Our Ref: F/9/20/DOC

Town & Country Planning Act 1990 (as amended)
Town and Country Planning (Development Management Procedure) (England) Order 2015
Approval of details reserved by condition imposed under ref F/30/18/PL relating to Condition No 3 -
surface water drainage.
Wicks Farm Ford Lane Ford BN18 0DF

Arun District Council have decided to **REFUSE details reserved by condition for the following reasons:**
This condition cannot be discharged on the basis of the information submitted to date for the following reasons :

PROPOSED DRAINAGE LAYOUT PART 3

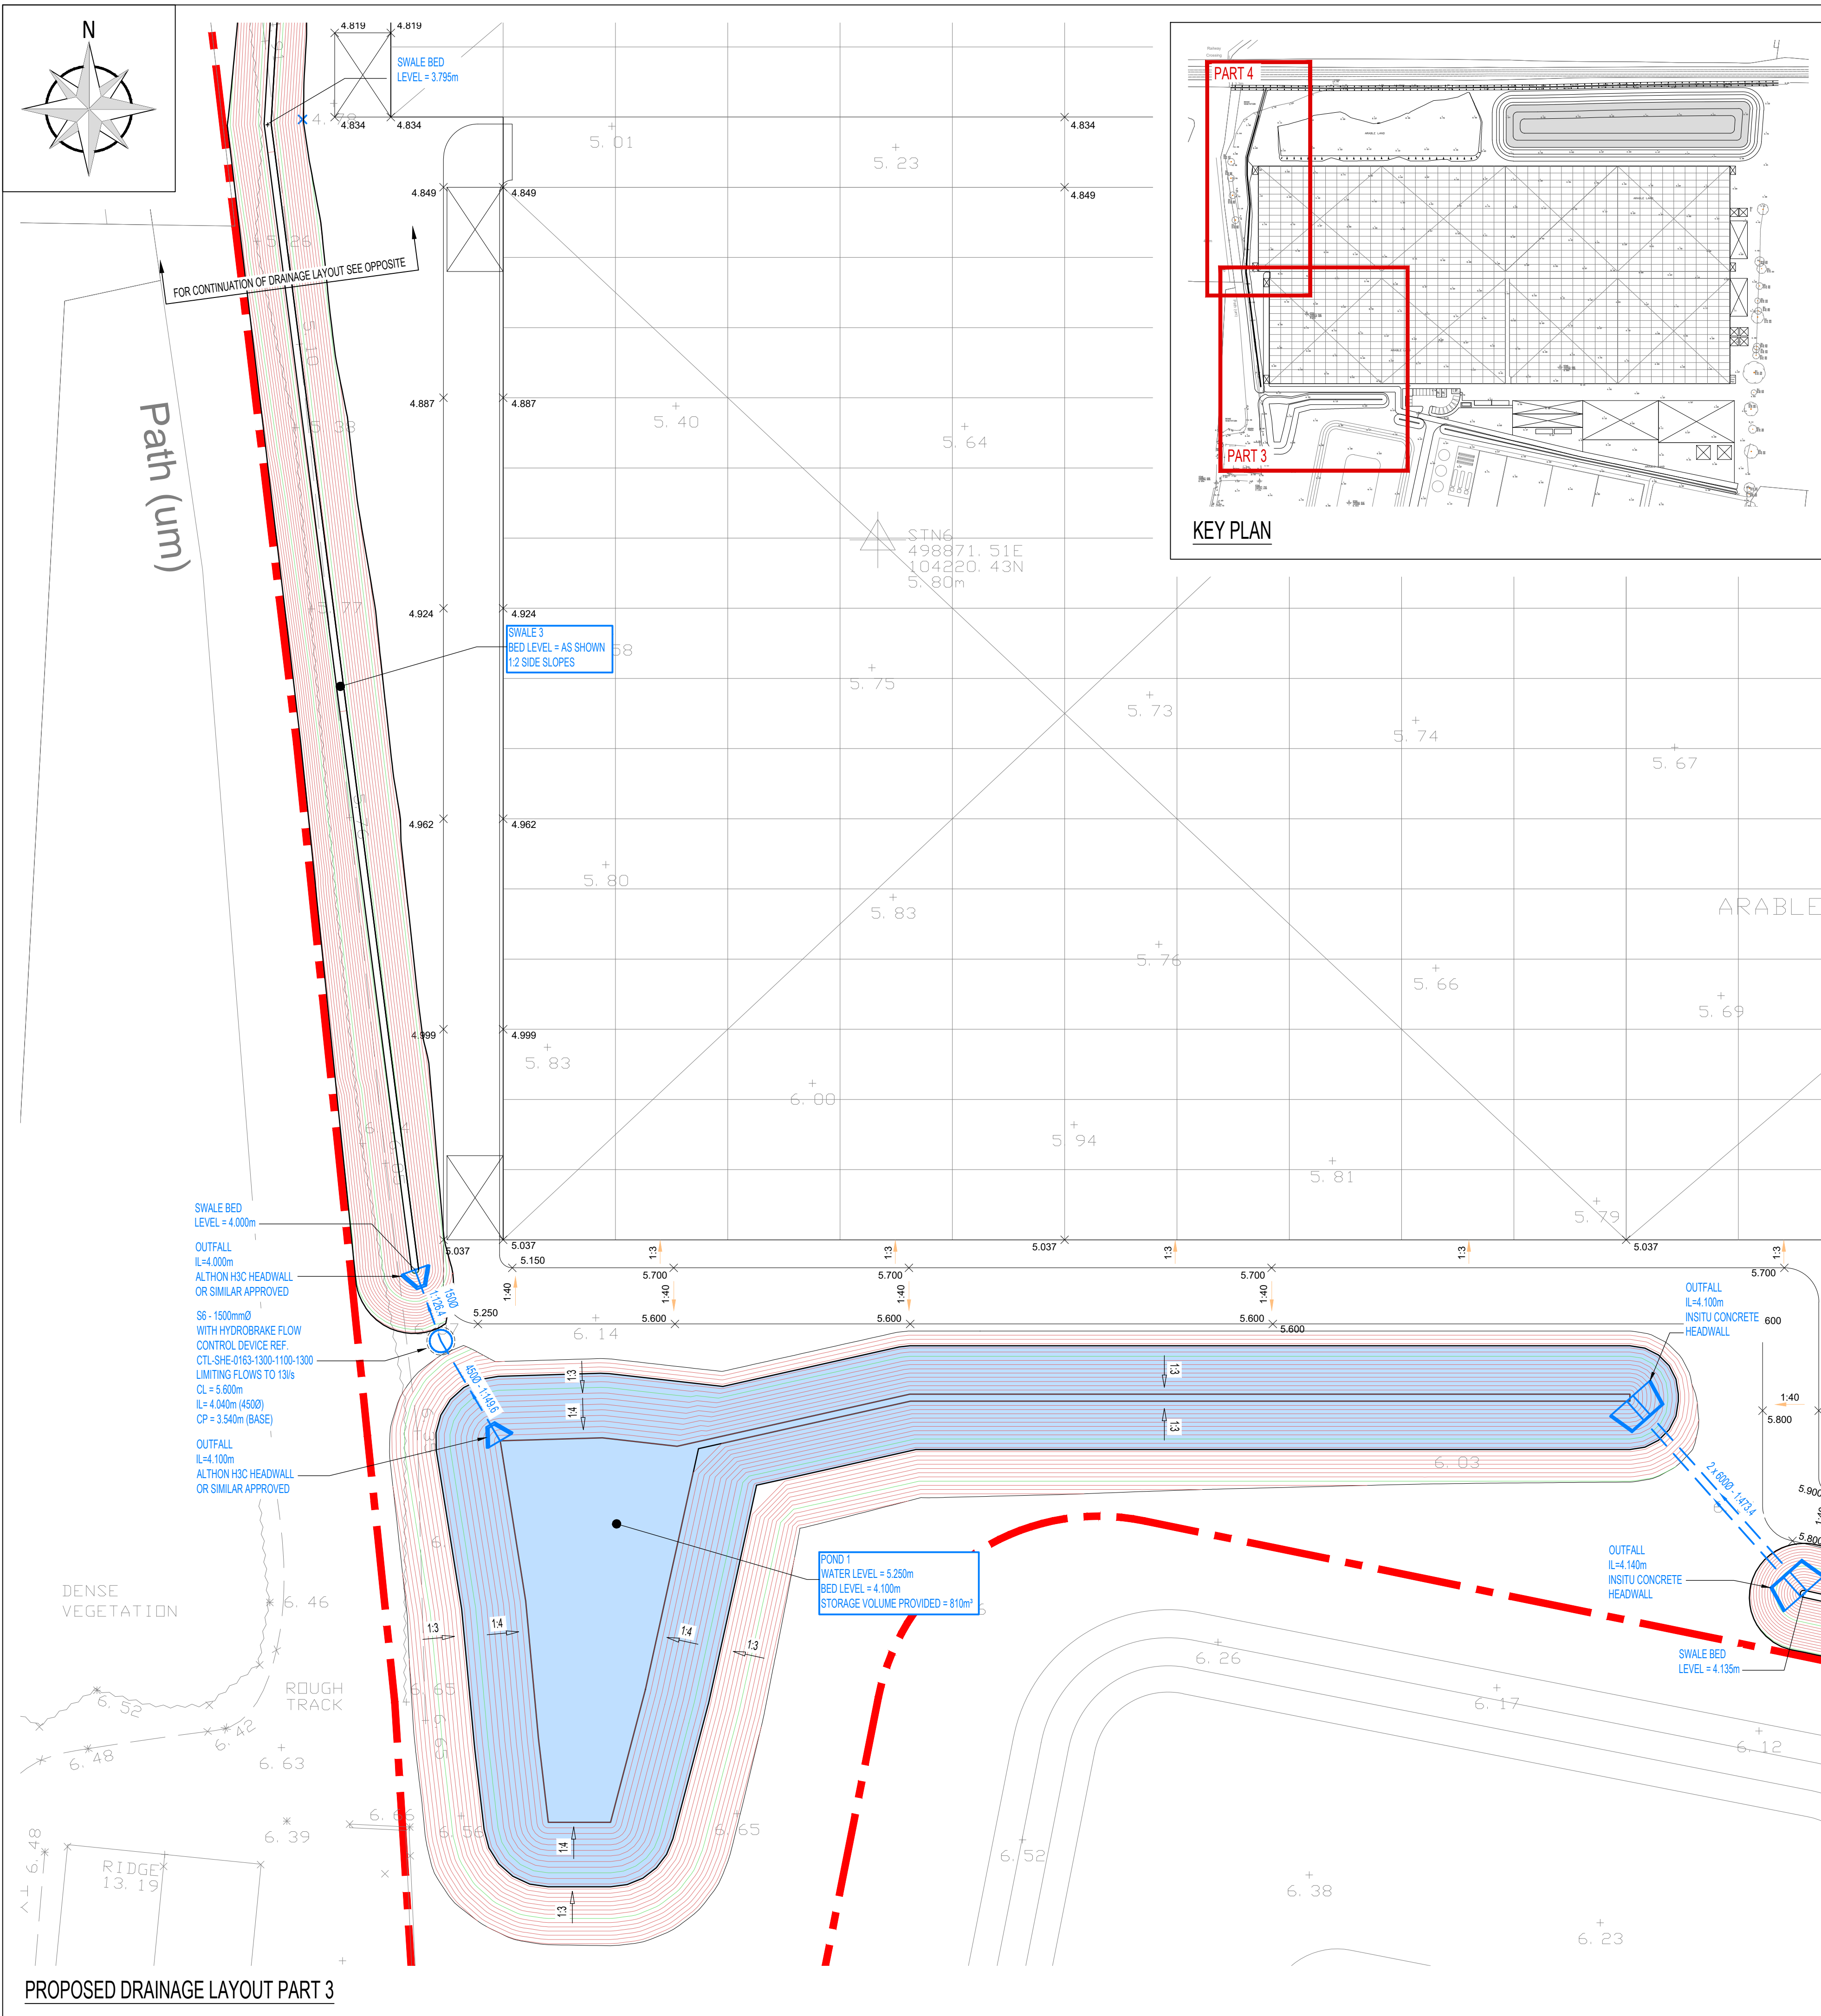
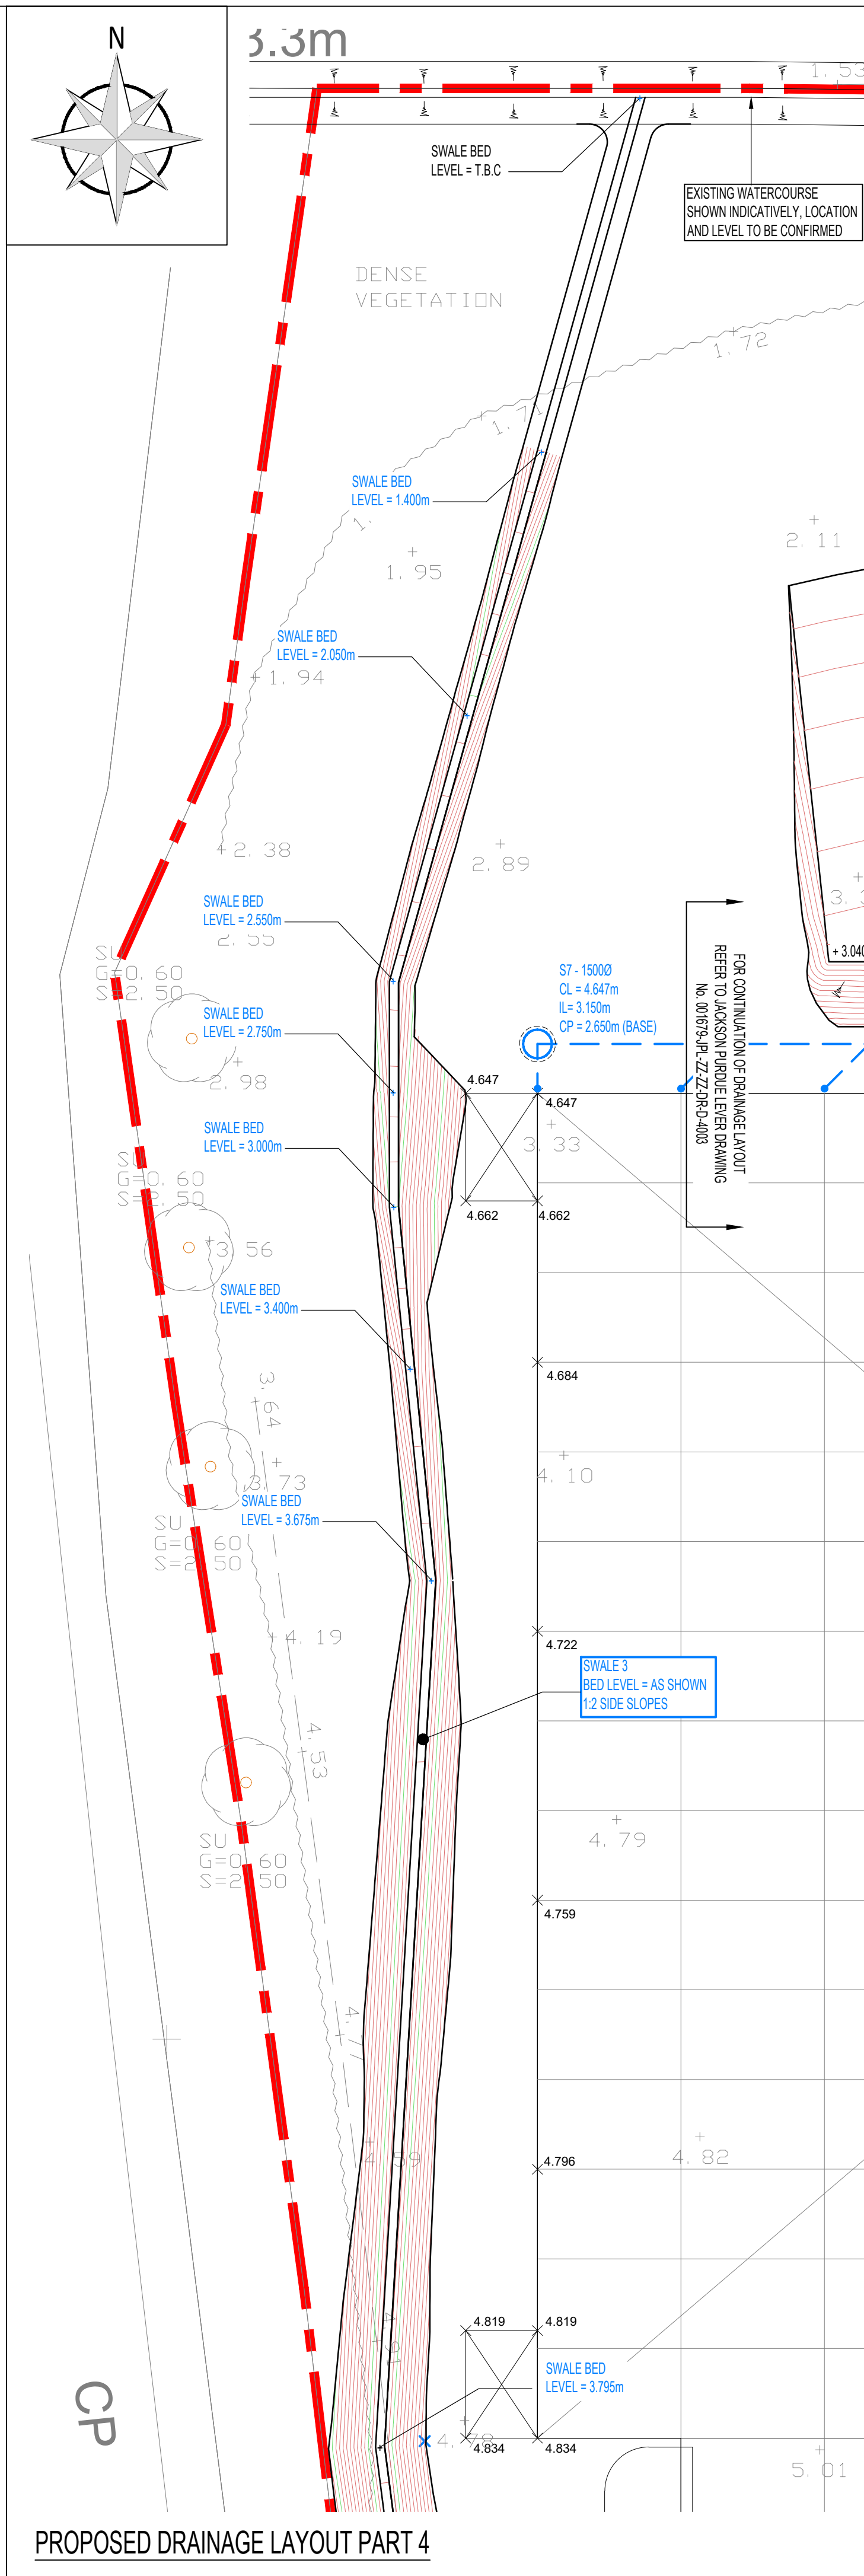
1. The northern boundary ditch in vicinity of the proposed reservoir is currently located on the other side of the network rail fence and not within the redline boundary. As previously suggested a new ditch will be required within the red line boundary and running parallel to the network rail ditch. Please adjust drawings and provide a typical profile cross section. Land drainage consent is also required for the new ditch and headwall outlet.

2. The pipe outlet invert (1.500) from the reservoir is currently shown below ditch bed level.
3. Adequate freeboard (ie. min 300mm) is required between the predicted top water levels in the reservoir and top of bank ie. may need to lower outlet level. Also, ensure the hydrobrake design head takes account of any adjustments to the design to achieve this.

5. Overflow pipe from reservoir provide headwall with cranked grille with bar spacings to suit 150mm diameter pipe. Include construction detail.
6. Specify gradient between overflow pipe and hydrobrake chamber.

9. RWP inlets Headwalls required. Specify diameters/gradients/invert levels. Provide construction details for headwalls. Fully detail pipework/manholes upstream between guttering and connection/s to reservoir. Silt traps required prior to entry to reservoir (provide construction details).

TYPICAL SECTION SHOWING POND 1 PROFILE

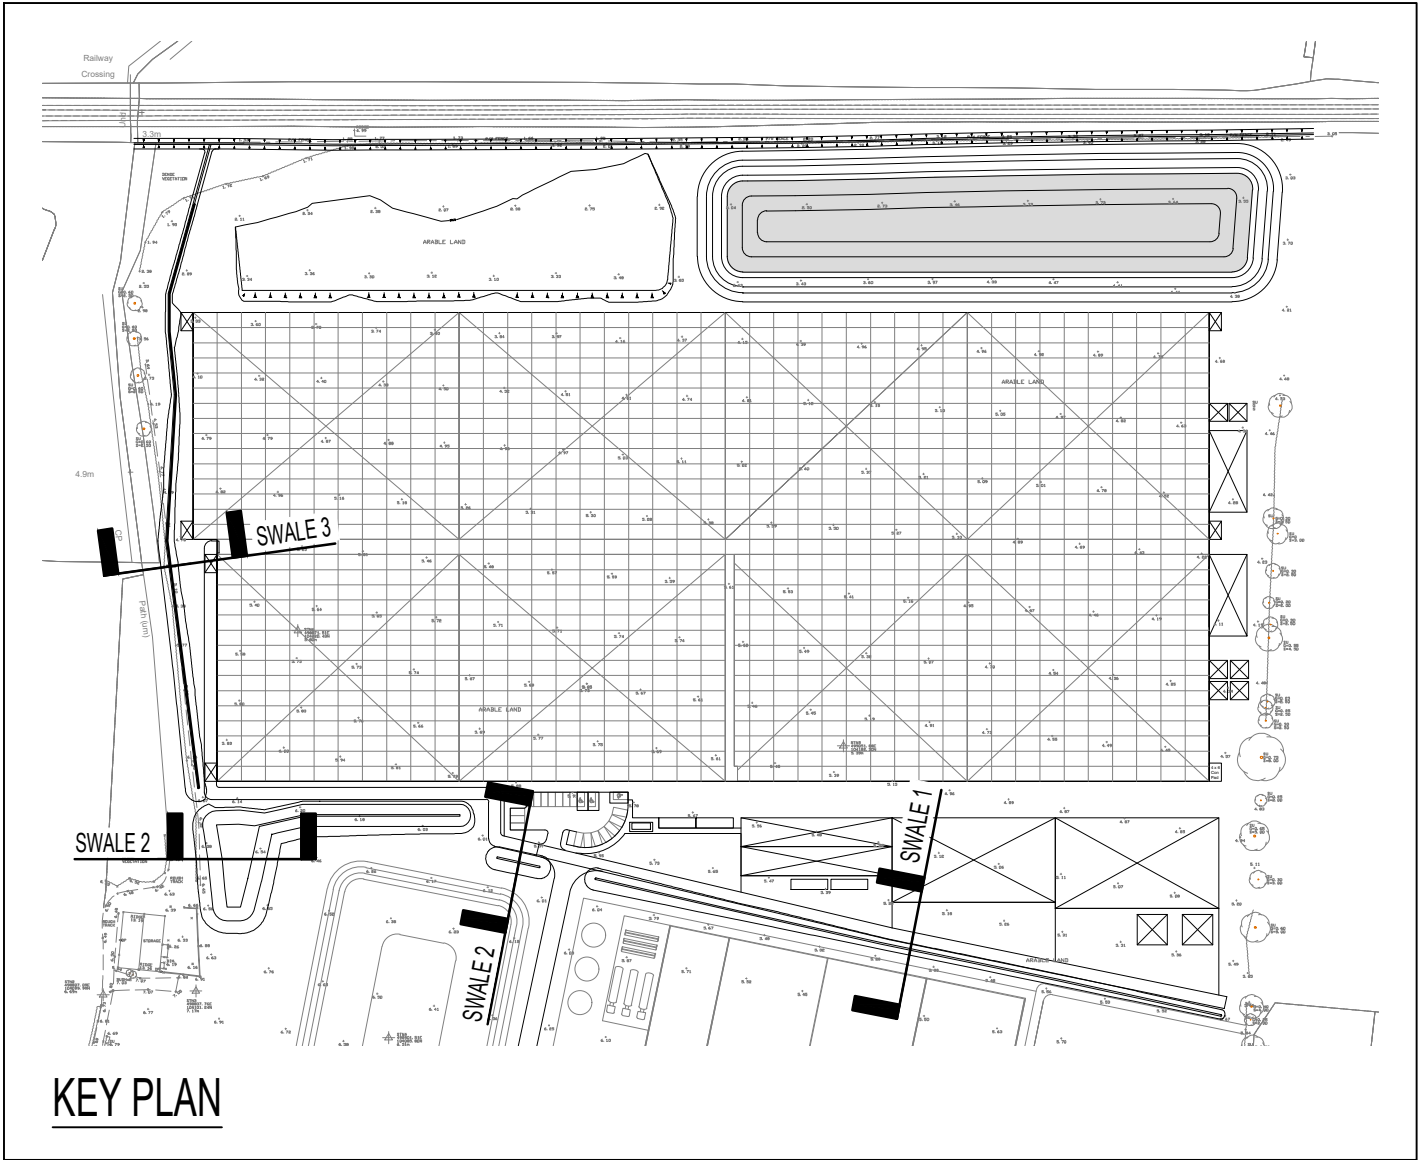
18. The pond/swale needs a slight gradient east to west (as has been employed on the upstream swales) to improve the hydraulics and ensure water movement. Please note the base level at the eastern end is currently lower than the base level at the western end. Adjust pipe inverts to suit.
